re: Grading & Servicing Plan Review
Proposed Multi-Storey Building
150 Laurier Avenue West – Ottawa, Ontario

file: PG5195-MEMO.02

REV # 2 122133-GR

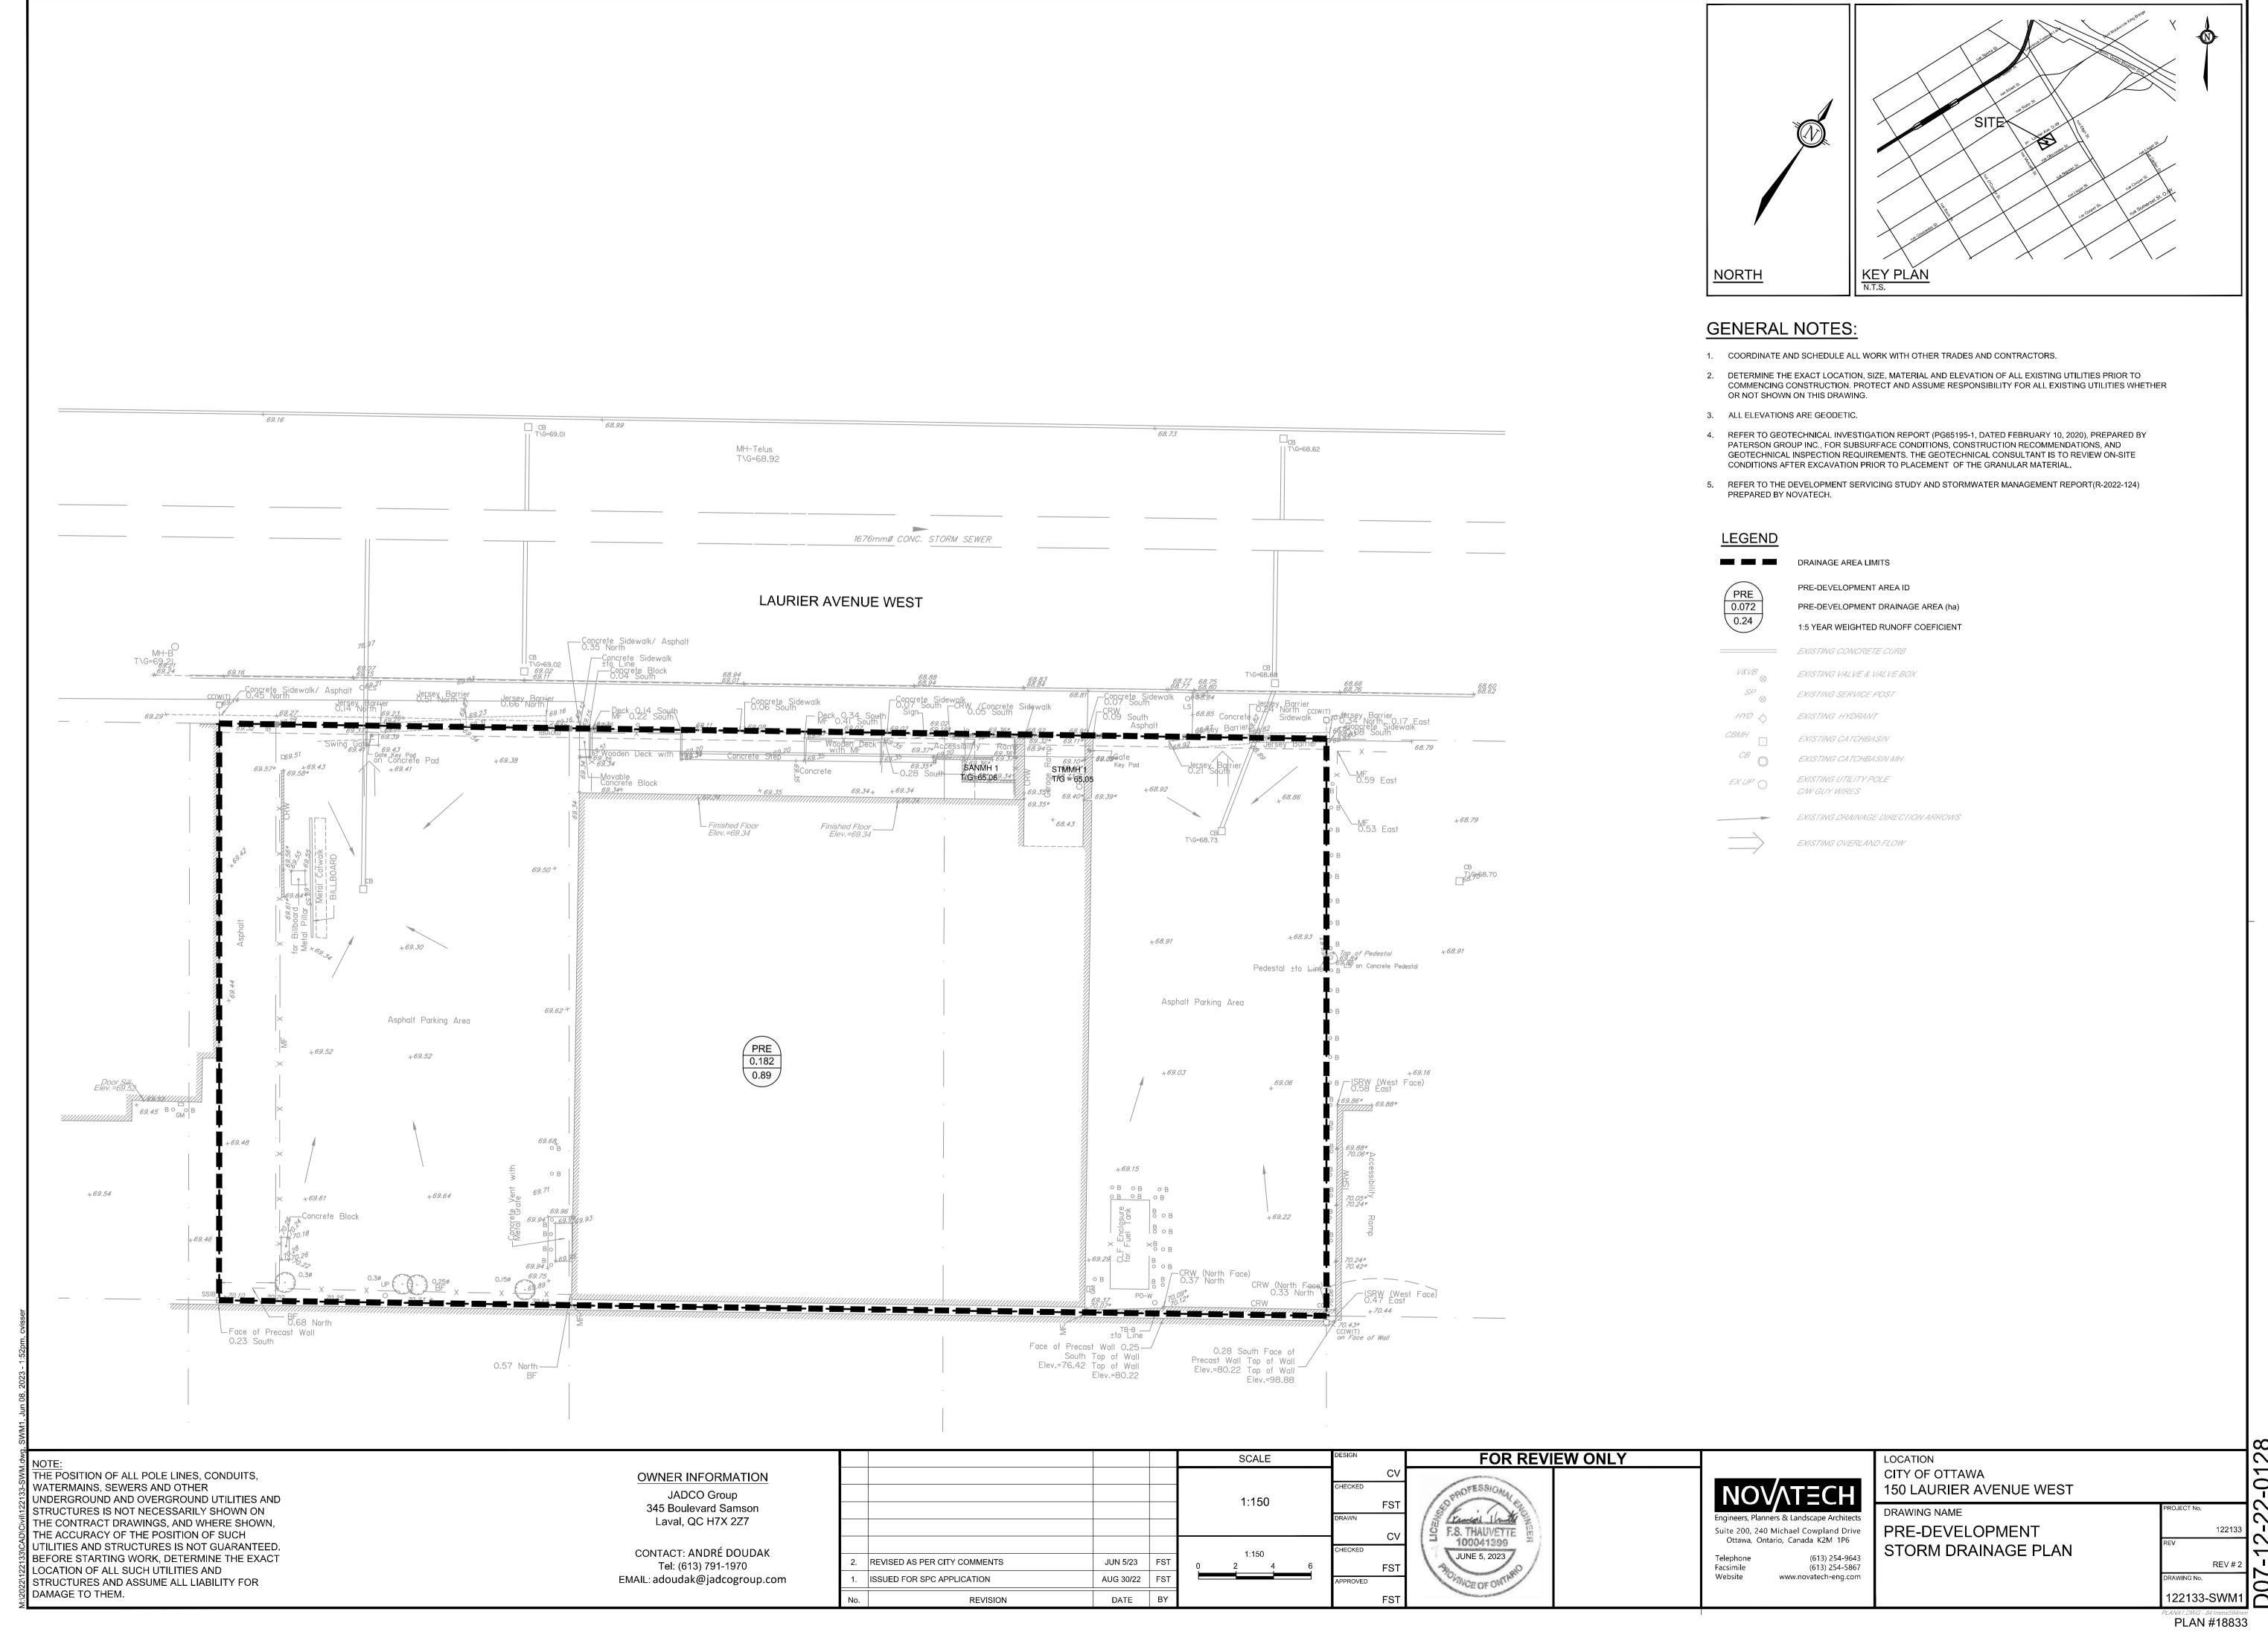
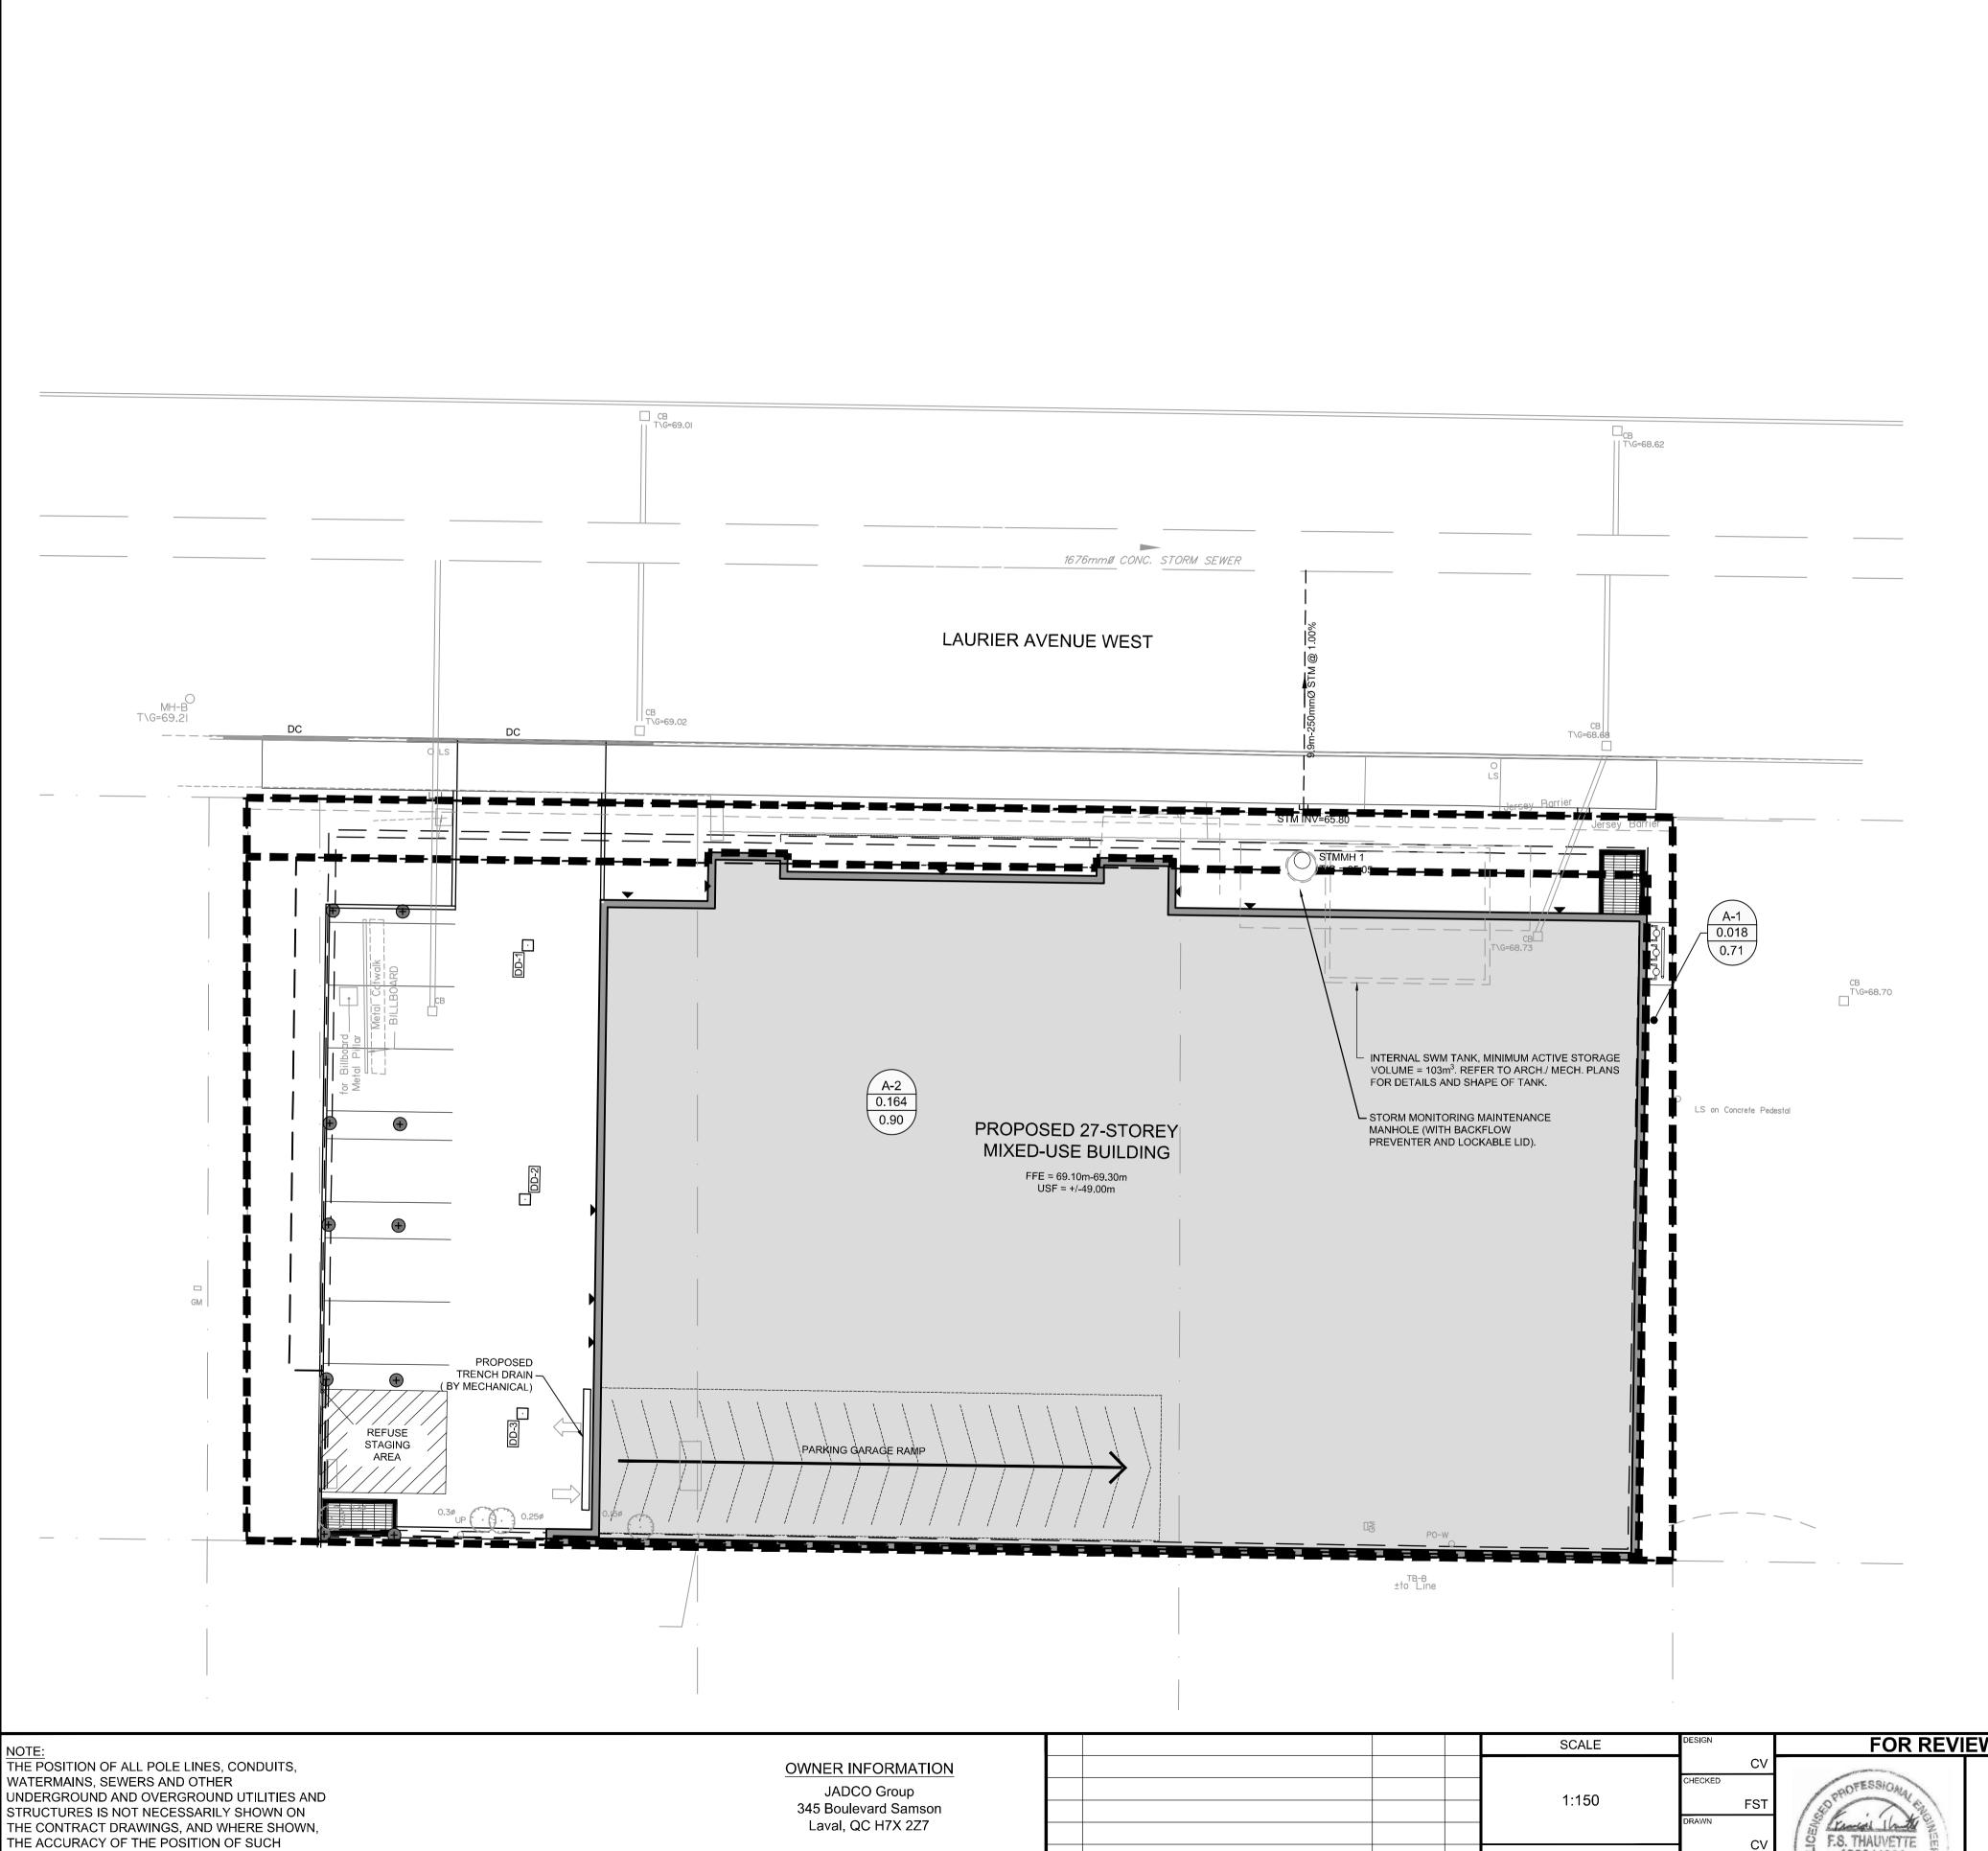
- Grading and Erosion & Sediment Control Plan – 150 Laurier Avenue West, Ottawa – Project No. 122133 – Drawing No. 122133-GR – Revision 2 dated June 5, 2023.

All overburden soils will be removed as part of excavation for the building construction. As such, permissible grade raises are not required at the subject site. Based on our review of the above-noted grading plan drawing and the subsurface conditions present at the subject site, the grading is considered acceptable from a geotechnical perspective.
